SPR EA1N and EA2 PROJECTS

DEADLINE 9 – COMMENTS ON CAH3 SUBMISSIONS

Interested Party: SASES PINS Refs: 20024106 & 20024110

Date: 15 April 2021 Issue: 1

Land Plans (Onshore)
Sheet Number: Sheet 2 of 12

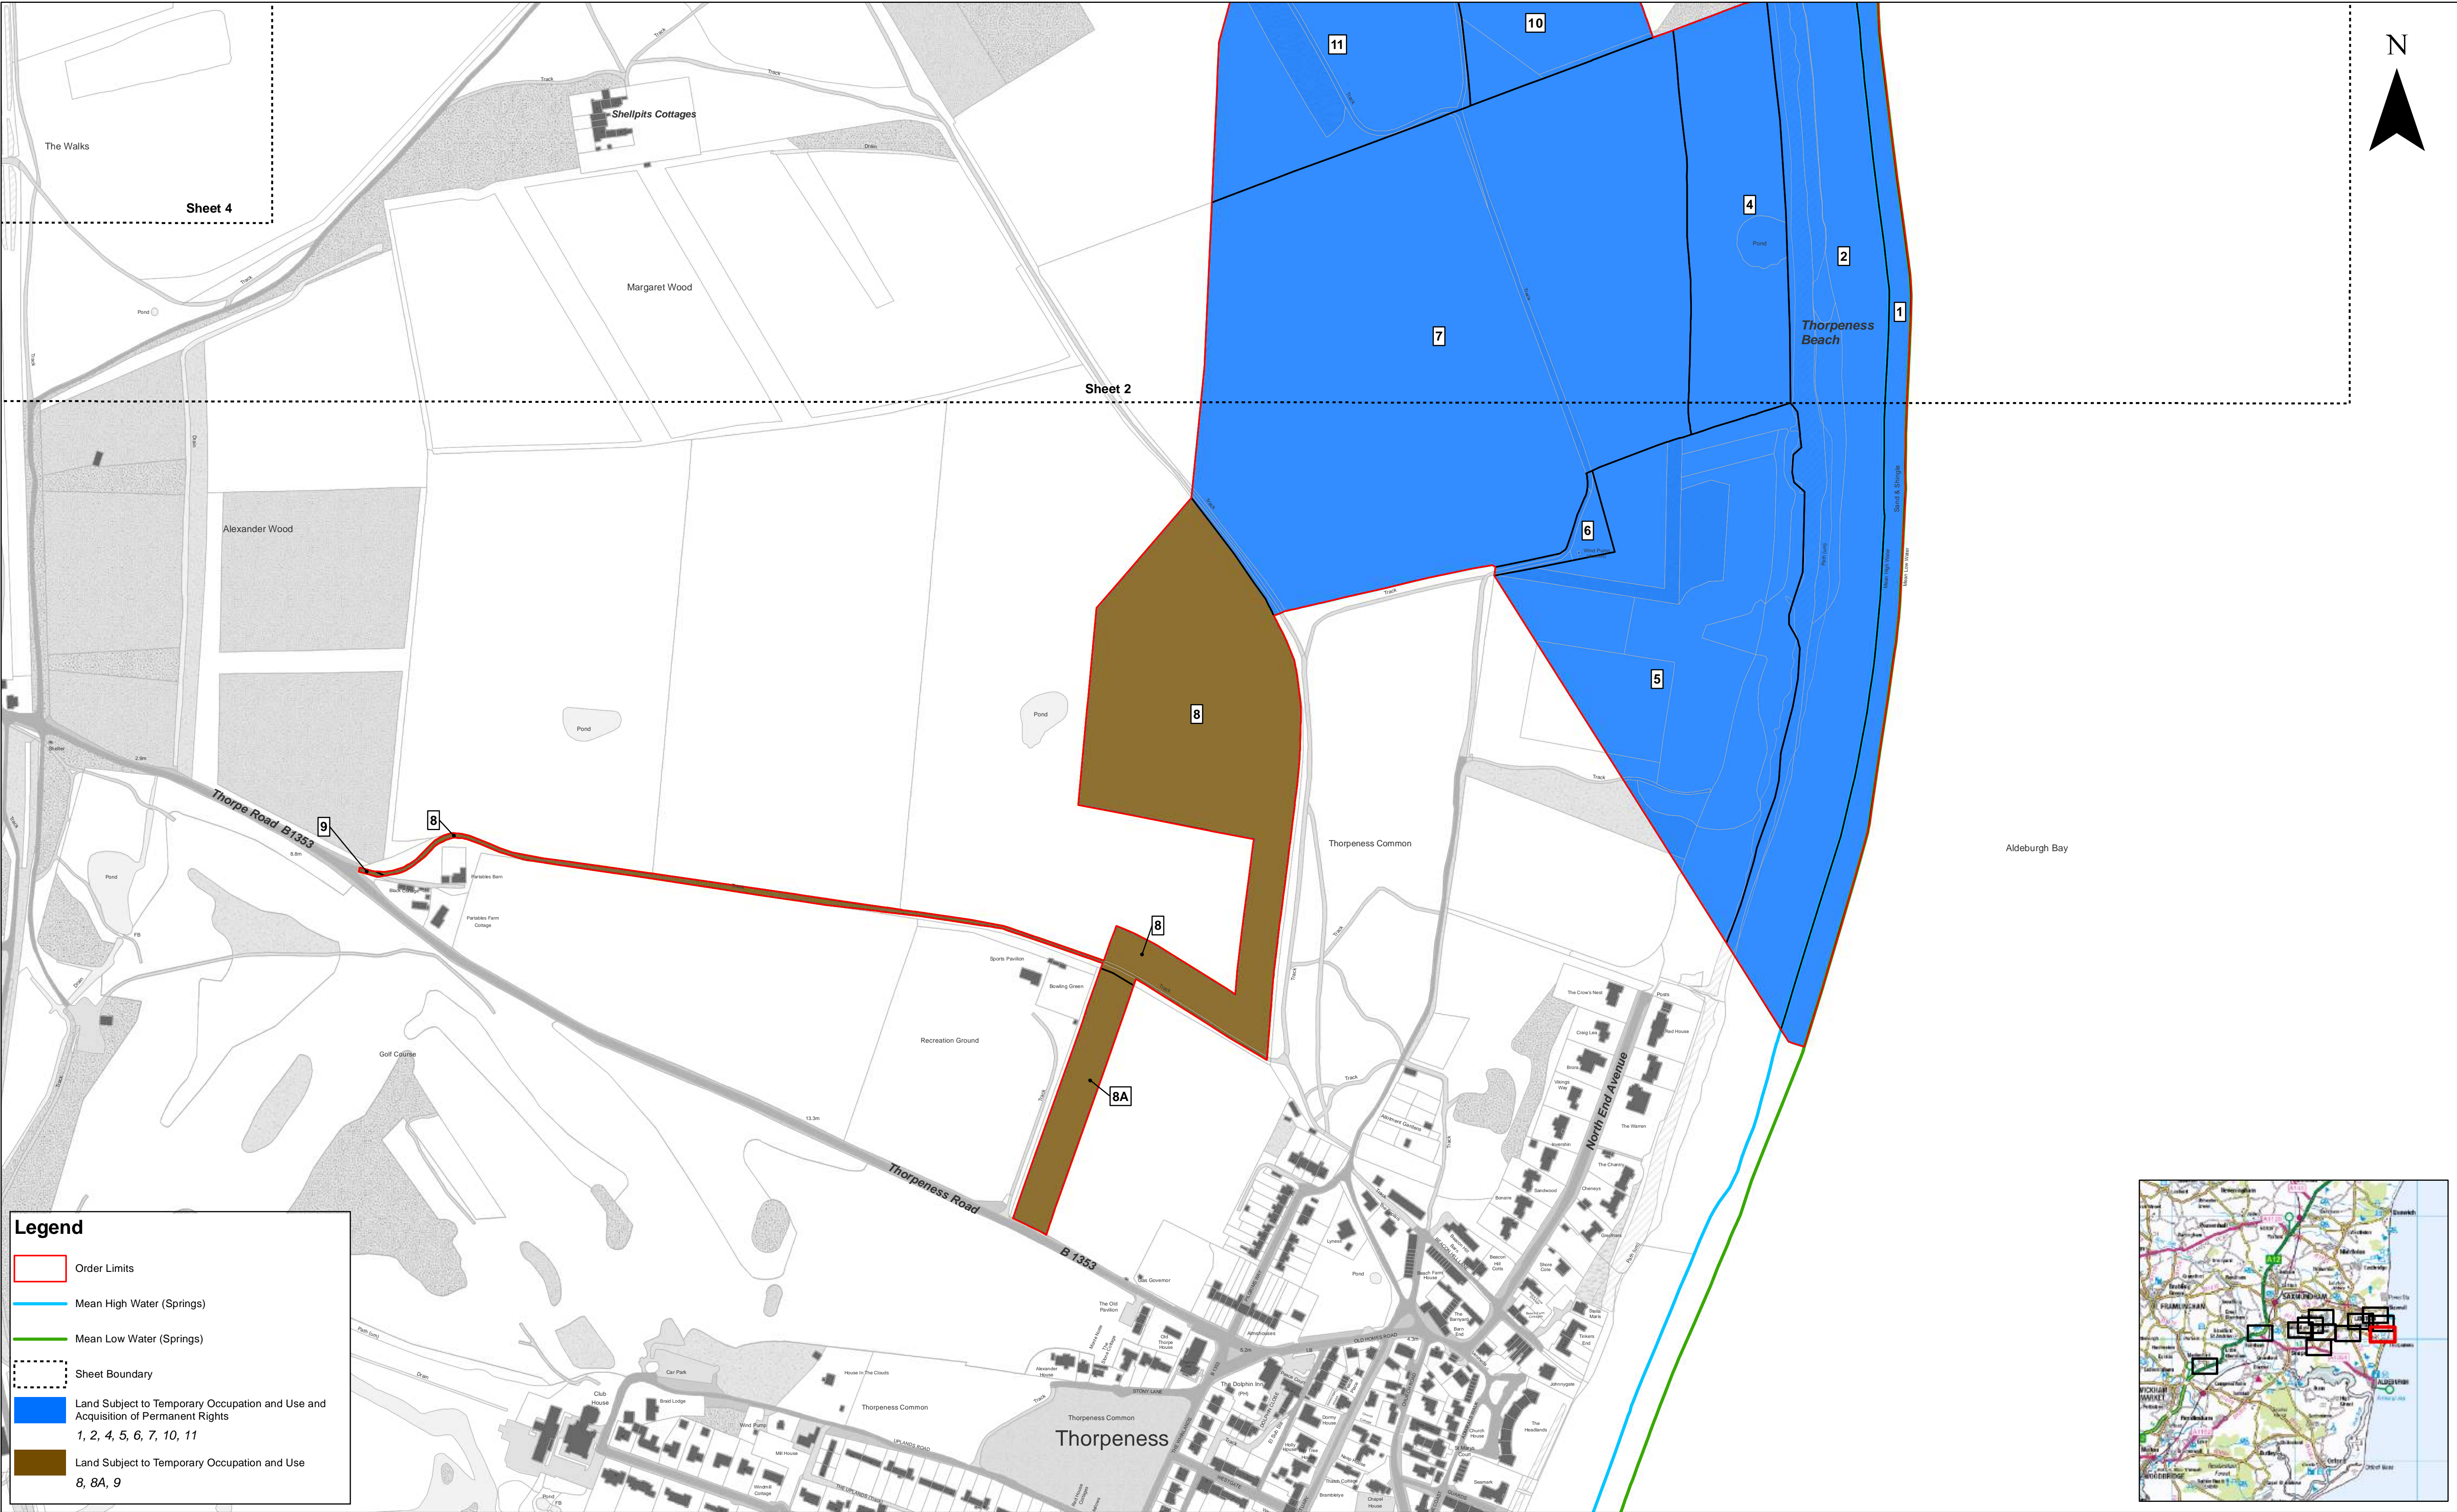
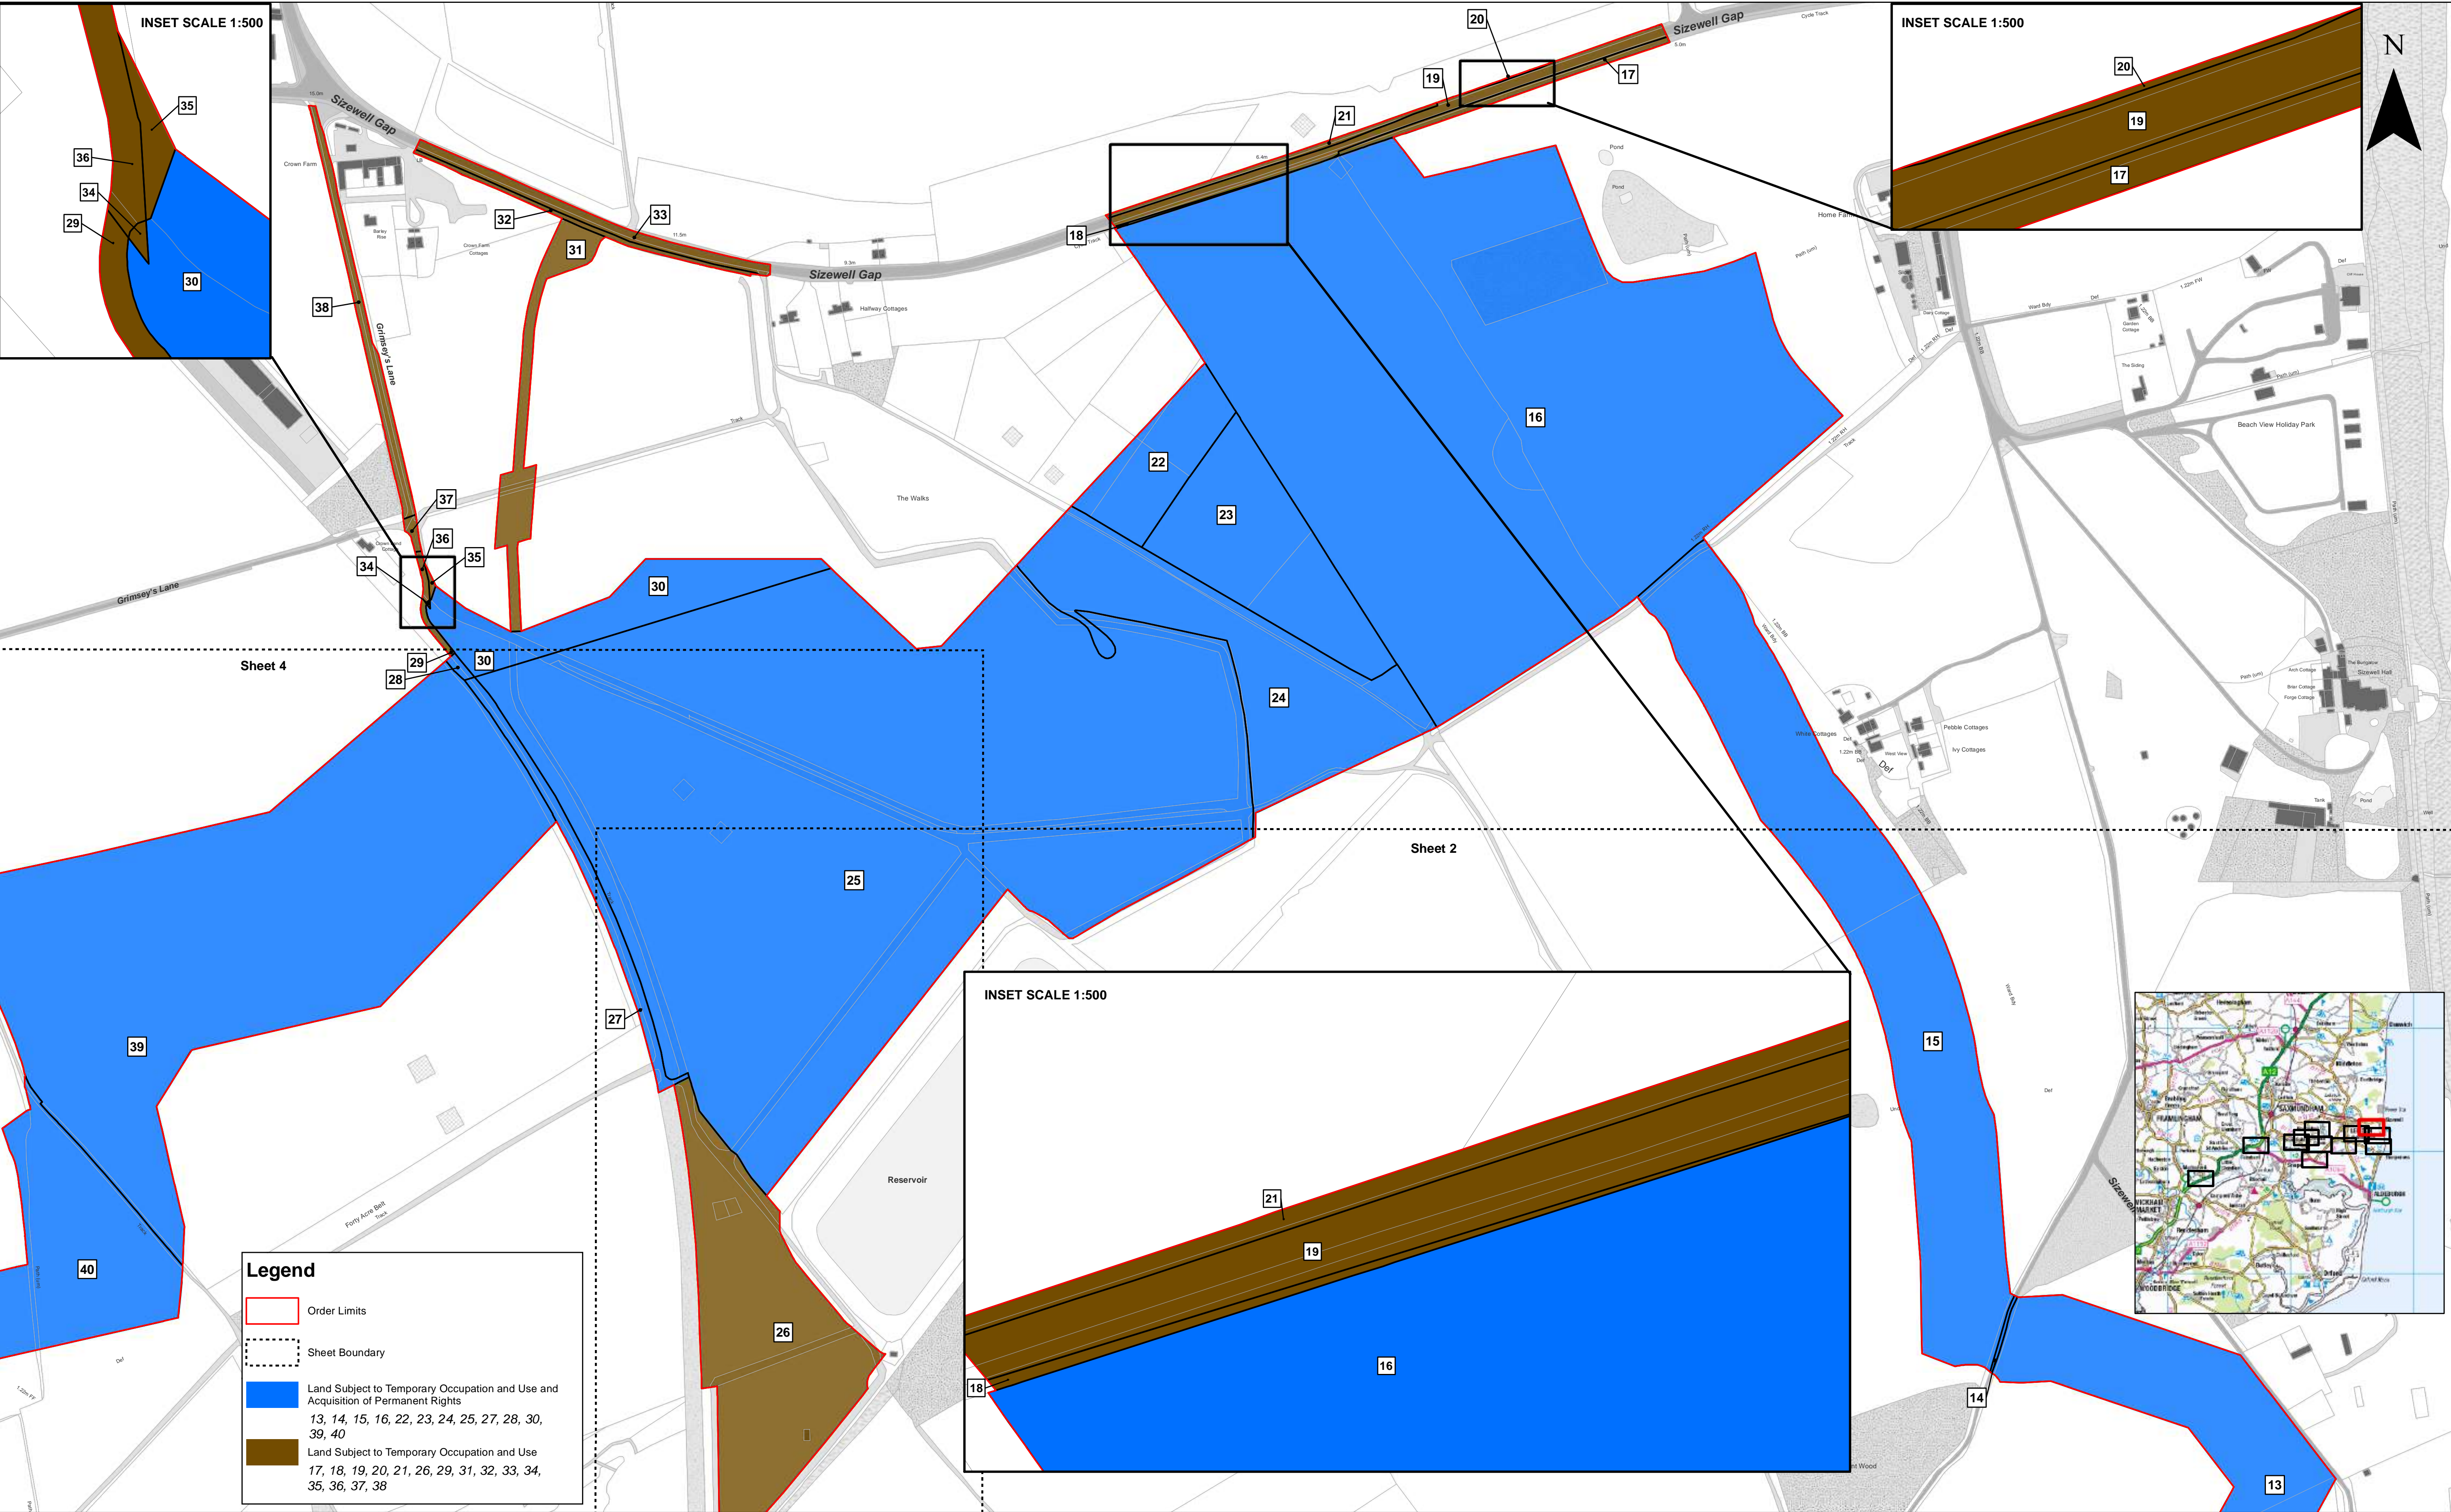
19. However, on examination of EA1N/EA2 Land Plans Rev 04, in conjunction with Suffolk Definitive Maps and Statement of public rights of way and views from Google Earth, only circa 770m of those sections of the 9.2Km cable corridor whose width is less than 75 are adjacent or even close to field boundaries. That immaterial potential saving of short 35m wide strips (at plots 13,15 and 85) cannot justify an excessive land take of 35 metres width over the remainder of the length of the cable corridors.
